Application by Oaklands Farm Solar Limited for an Order Granting Development Consent for Oaklands Farm Solar Park
The Examining Authority's third written questions and requests for information
Issued on Tuesday 12 November 2024

The following table sets out the Examining Authority's (ExA's) third set of written questions and requests for information (ExQ3).

Figure 1e: Habitat constraints plan

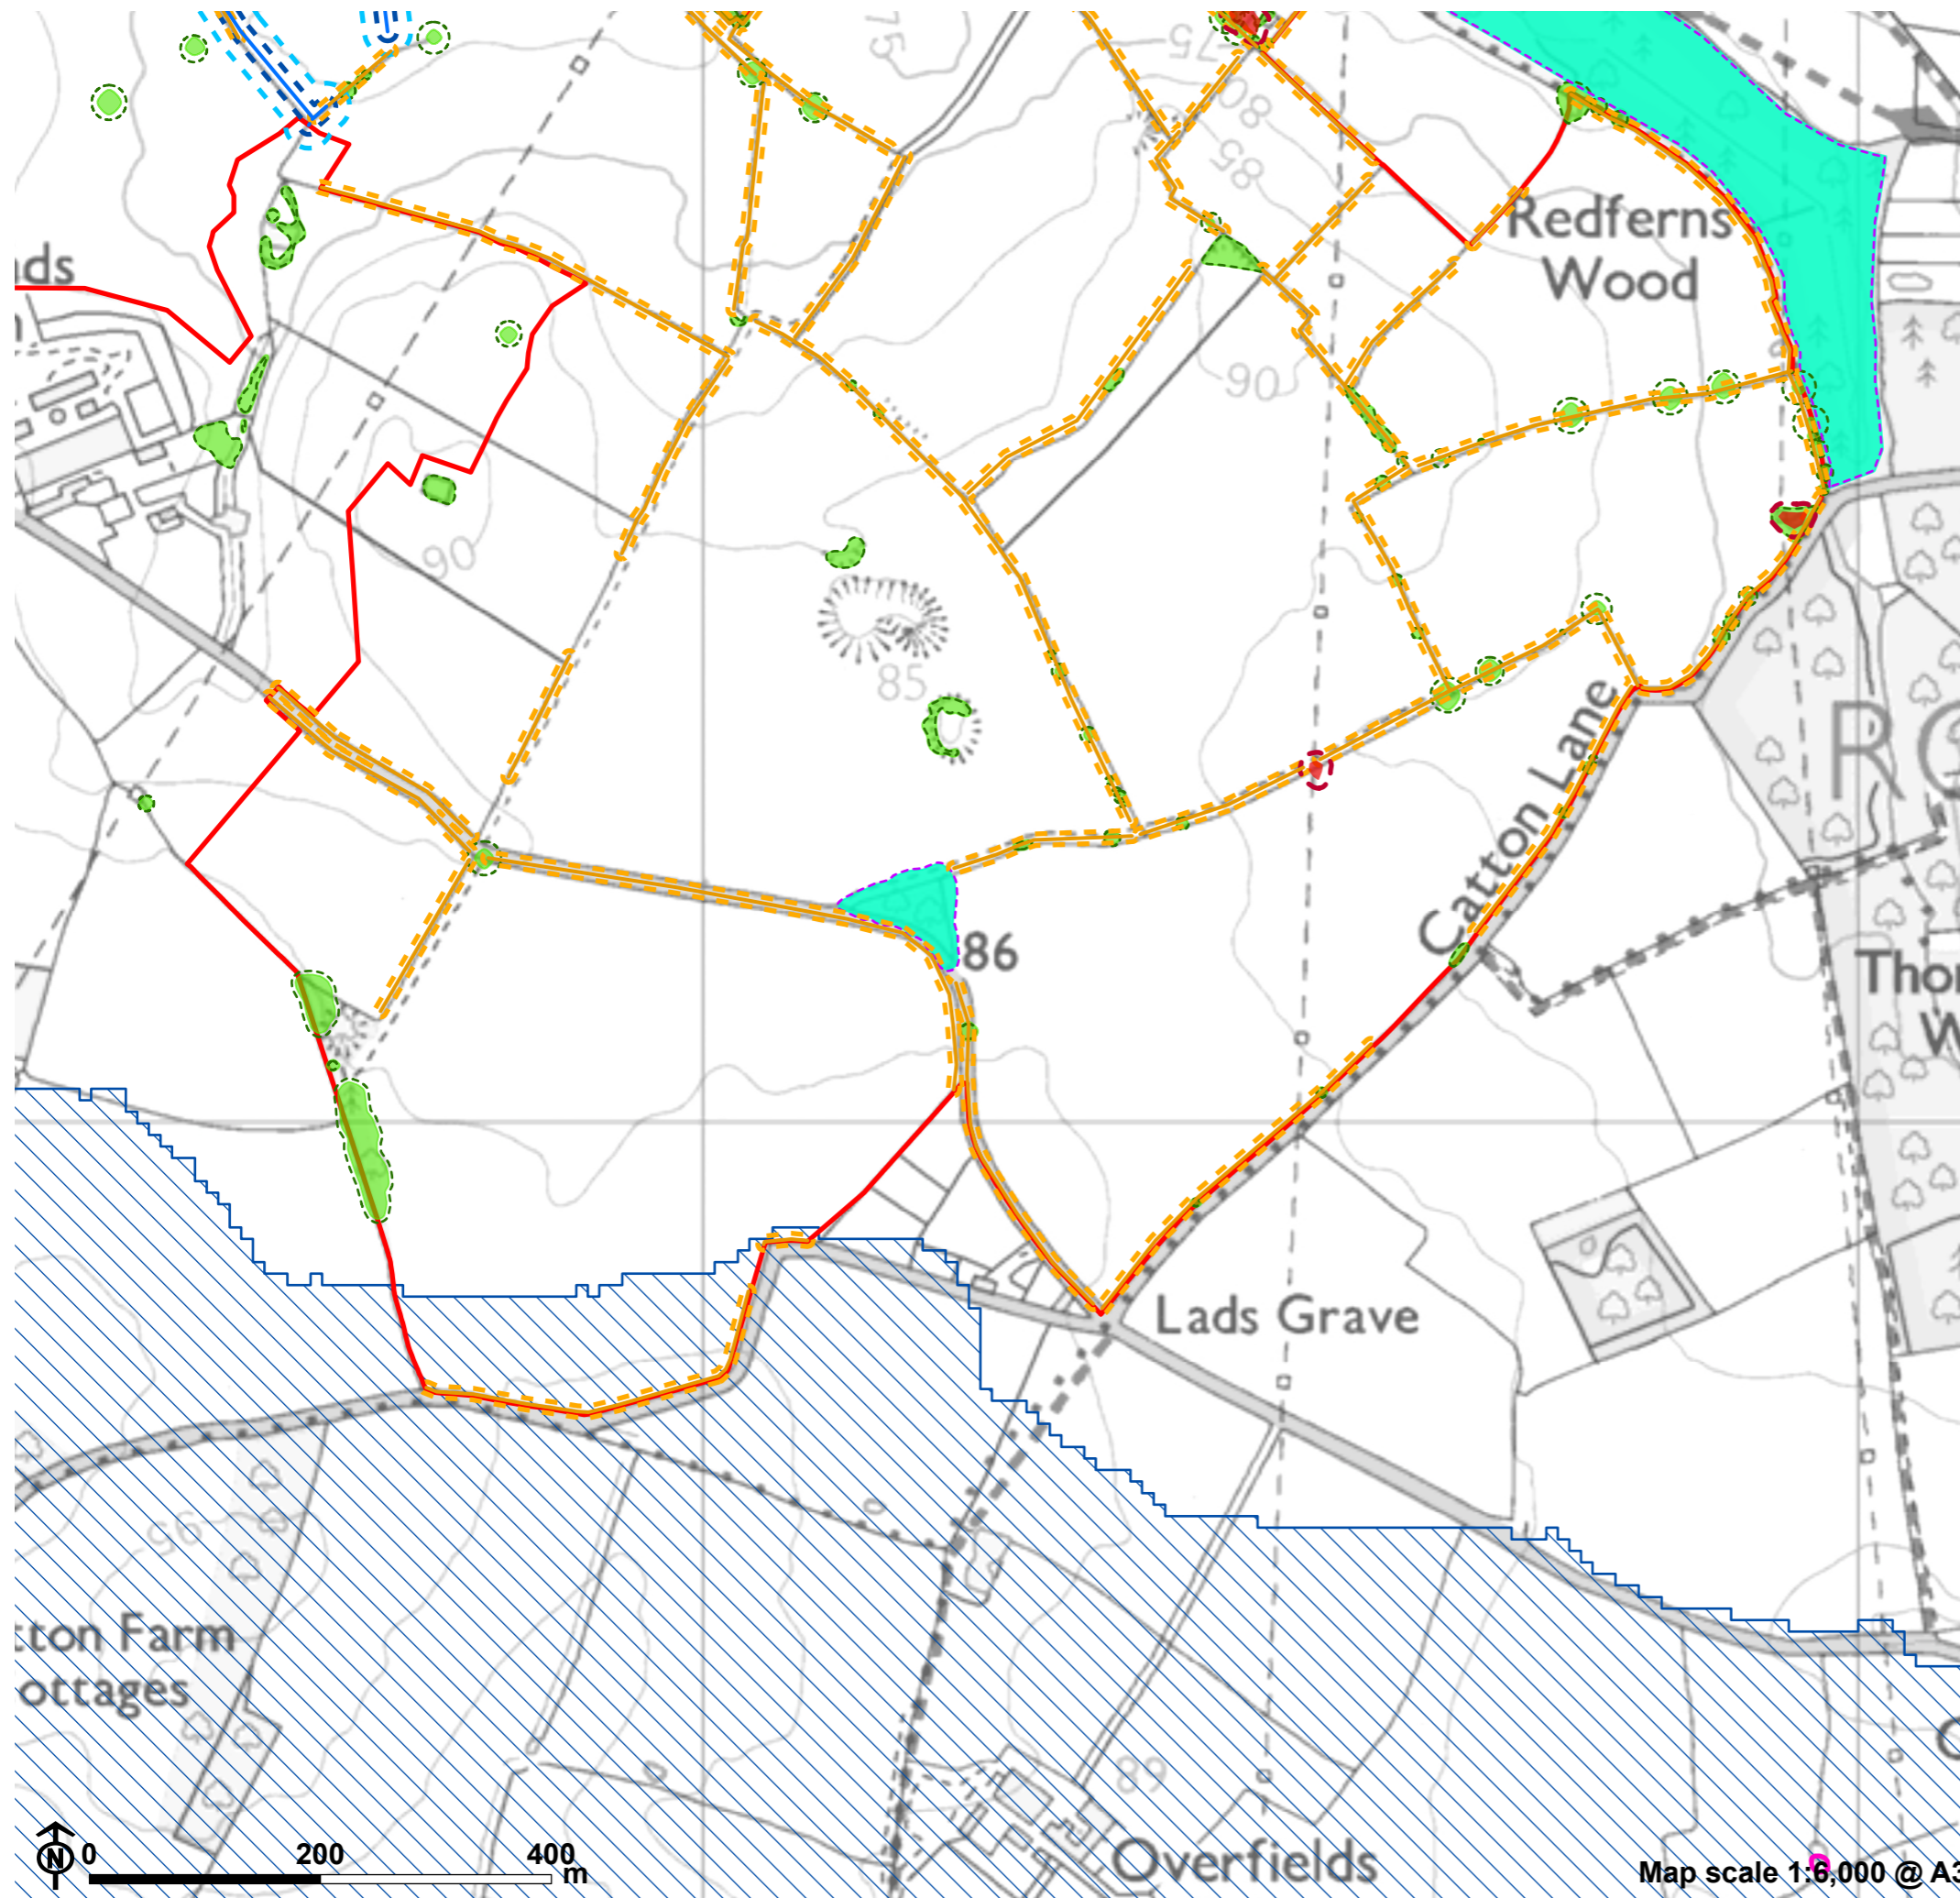
| Ref: | Question to: | Question: |
|------|--------------------------|---|
| 7.3 | Applicant SDDC DCC | <p><u>Habitat Constraints Plan</u></p> <p>SDDC [REP4-014] and DCC [REP4-012] referred to the need for a Habitat Constraints Plan with interpretable maps to provide the necessary details and extent of site clearance works relating to buffer zones to sensitive features such as ancient/ veteran trees, other retained trees, ponds, watercourses, hedgerows and woodlands.</p> <p>The Outline CEMP [REP5-011] includes provisions for a Habitats Constraint Plan [Section 2.8.5] and buffers [Sections 2.6.4, 2.6.5, 2.8.2, 2.8.3, 2.8.5, and 2.8.6]. The Applicant provides a series of interpretable maps of habitat constraints [REP5-030].</p> <ul style="list-style-type: none"> a) Please could the Applicant add the draft interpretable maps to the Outline CEMP [REP5-011] and secure that interpretable maps be included in the final CEMP? b) Please could SDDC and DCC comment? c) Please could SDDC and DCC also summarise any outstanding concerns at Deadlines 7 and 8 with suggestions about how they might be addressed? |
